From: Martyn White
Sent: 11 July 2019 17:08
To: Planning.Responses <Planning.Responses@arun.gov.uk>
Cc: Anita Gardner <Anita.Gardner@arun.gov.uk>
Subject: LU/174/19/PL

LU/174/19/PL

The proposal is for a replacement dwelling within the Littlehampton – seafront Conservation Area. I also note that the proposal is a revision of a previously approved scheme for a modern structure.

Project		
2A NORFOLK ROAD		
Status		
PLANNING		
Drawing		
SIDE ELEVATION (NORTH)		
Drwg No :	Scale :	Date :
381_20_231	1:50@A3	27/04/19

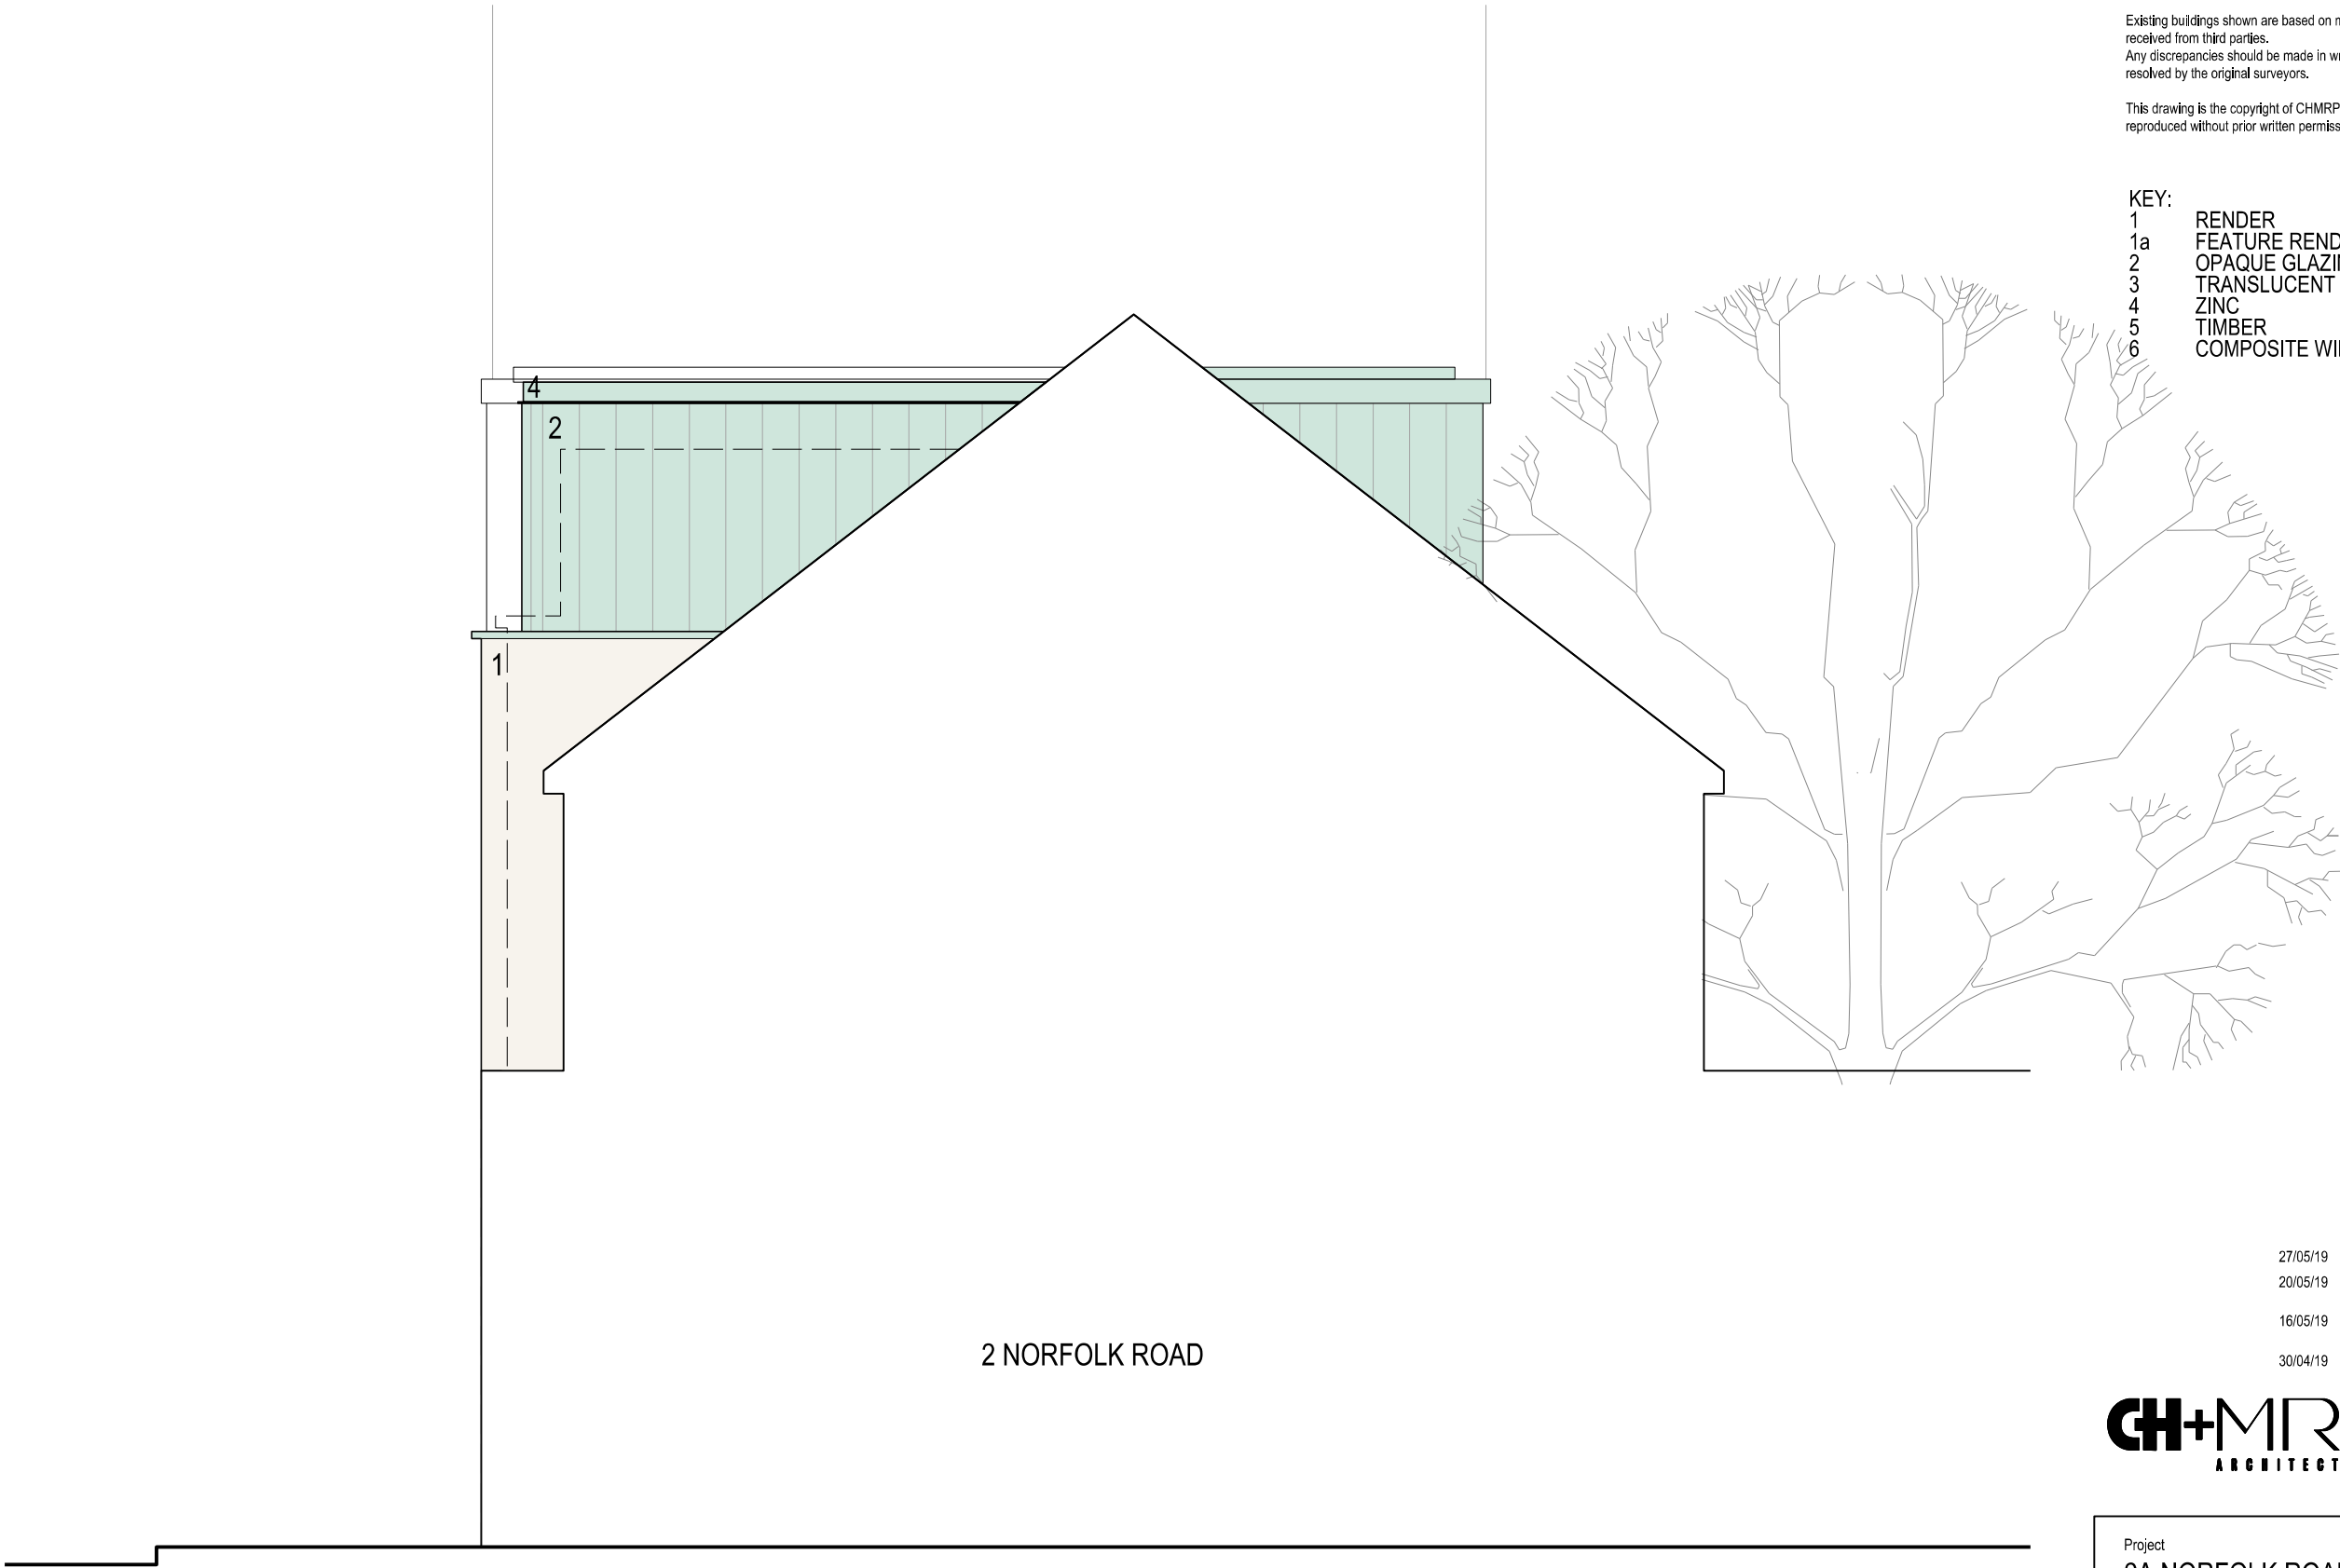
The replacement dwelling will be a modern three storey house which will be attached to an existing terrace. This dwelling will have a mixture of render and glazing (opaque and translucent). The use of render will ensure that it reflects those buildings in the local area, whilst the glazing will introduce a more modern design element, which will at the same time, help to reduce the mass of the building.

If minded to approve the application, details of the windows/glazing, the decorative render, and other design features should be provided to the council by way of condition. Drawings should be provided at an appropriate scale in order to ensure that it reflects the high quality required of such a development.

Drawing
STREETSCAPE COMPARISON

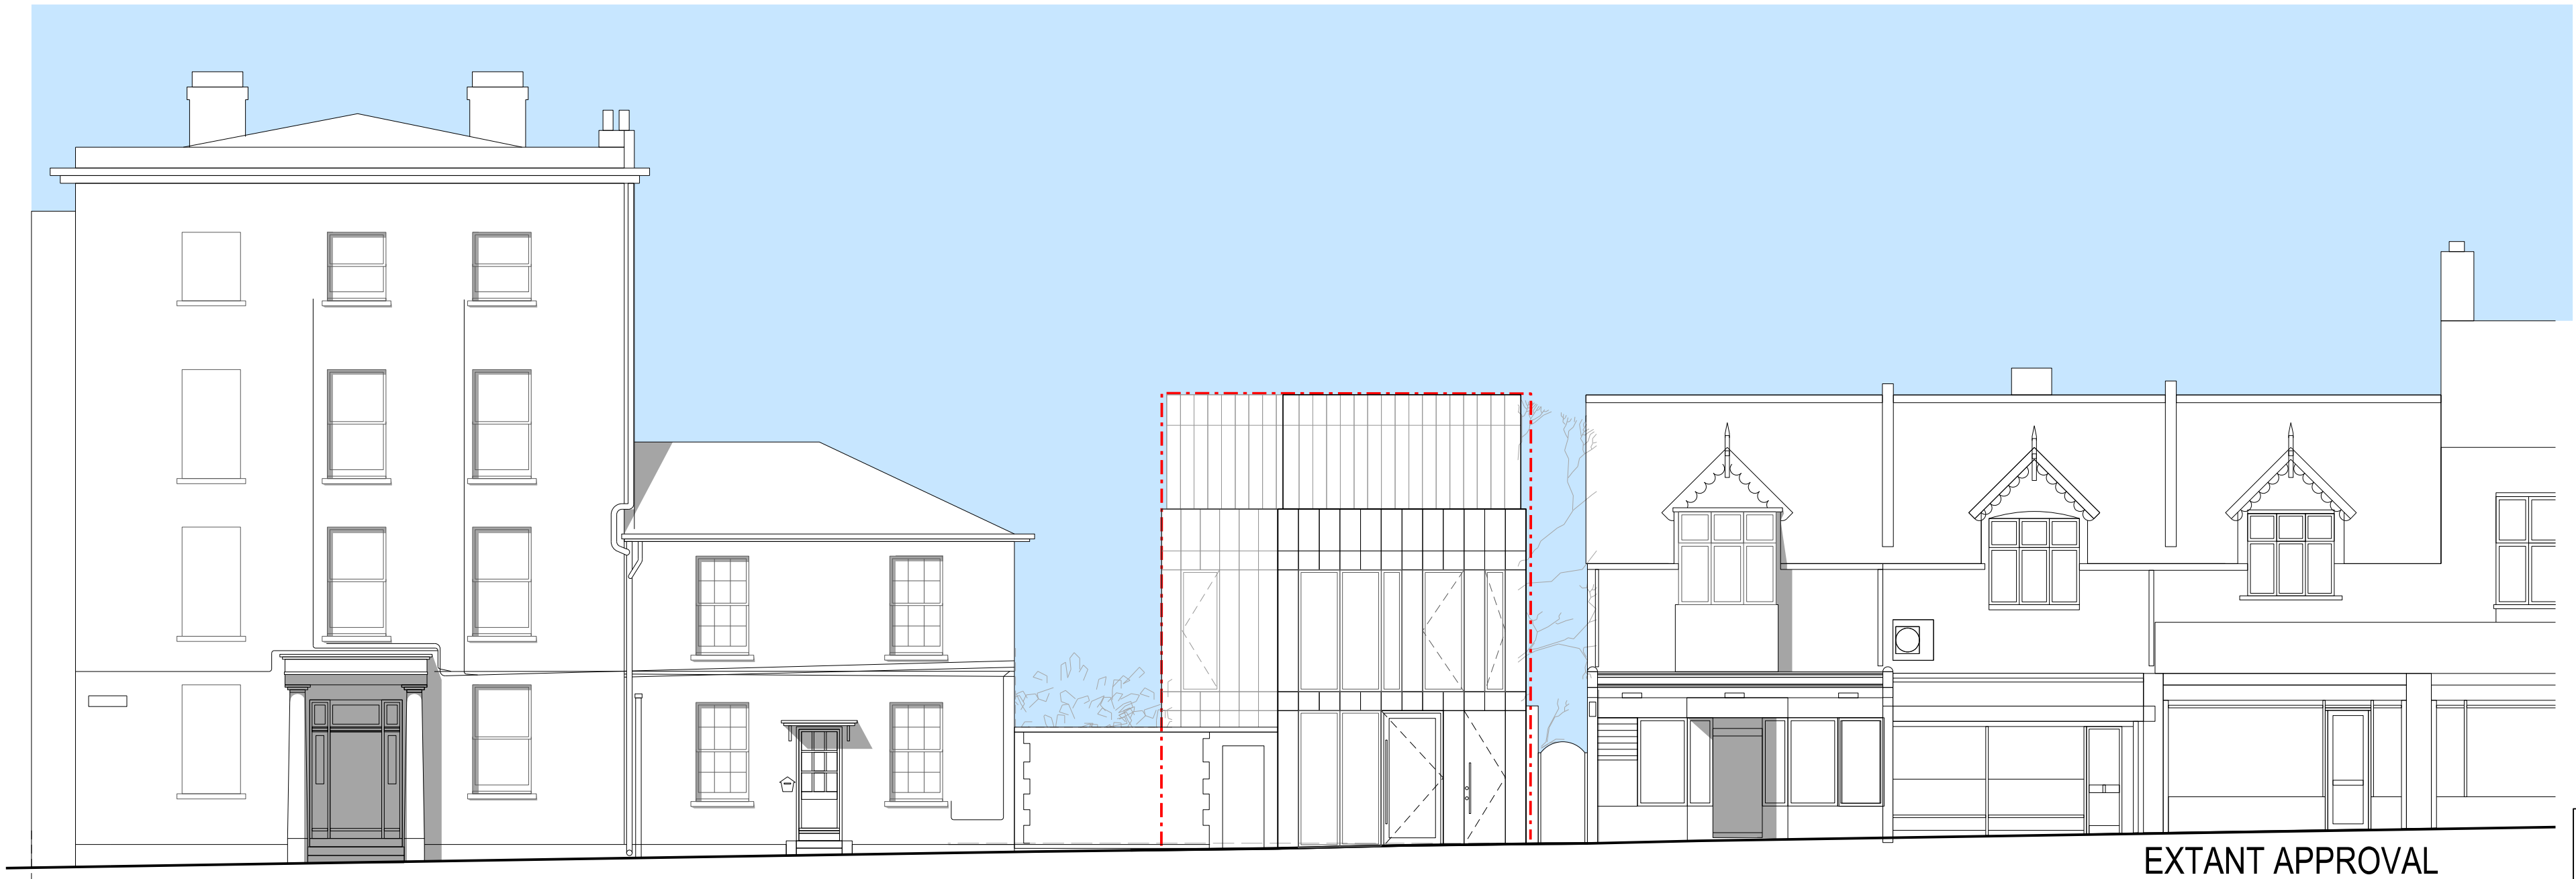
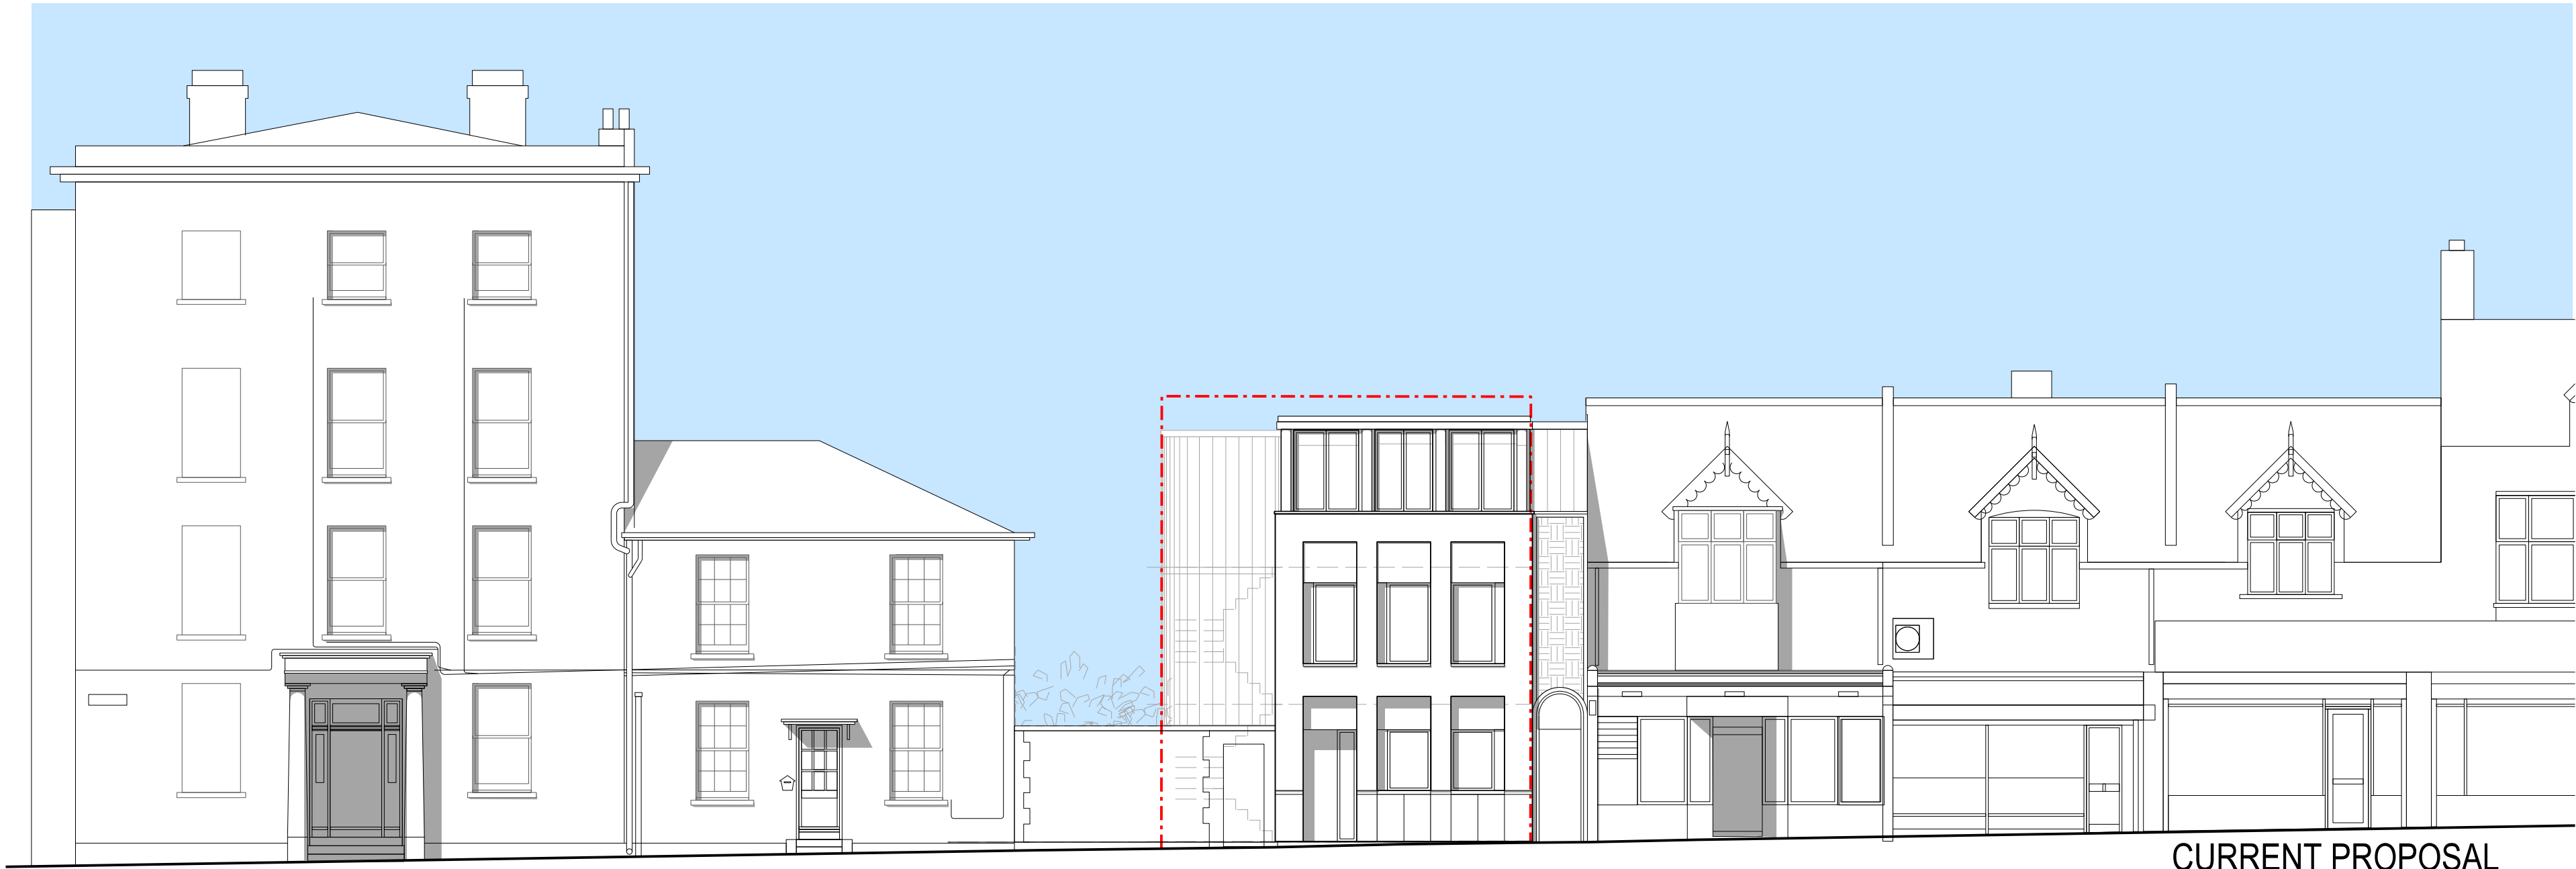
On balance, it is considered that the proposal will not have a detrimental impact upon the established character of the locality, or the neighbouring listed buildings. Further, the proposal will result in the enhancement of what is considered to be a site that does not make a positive impact to the character of the locality.
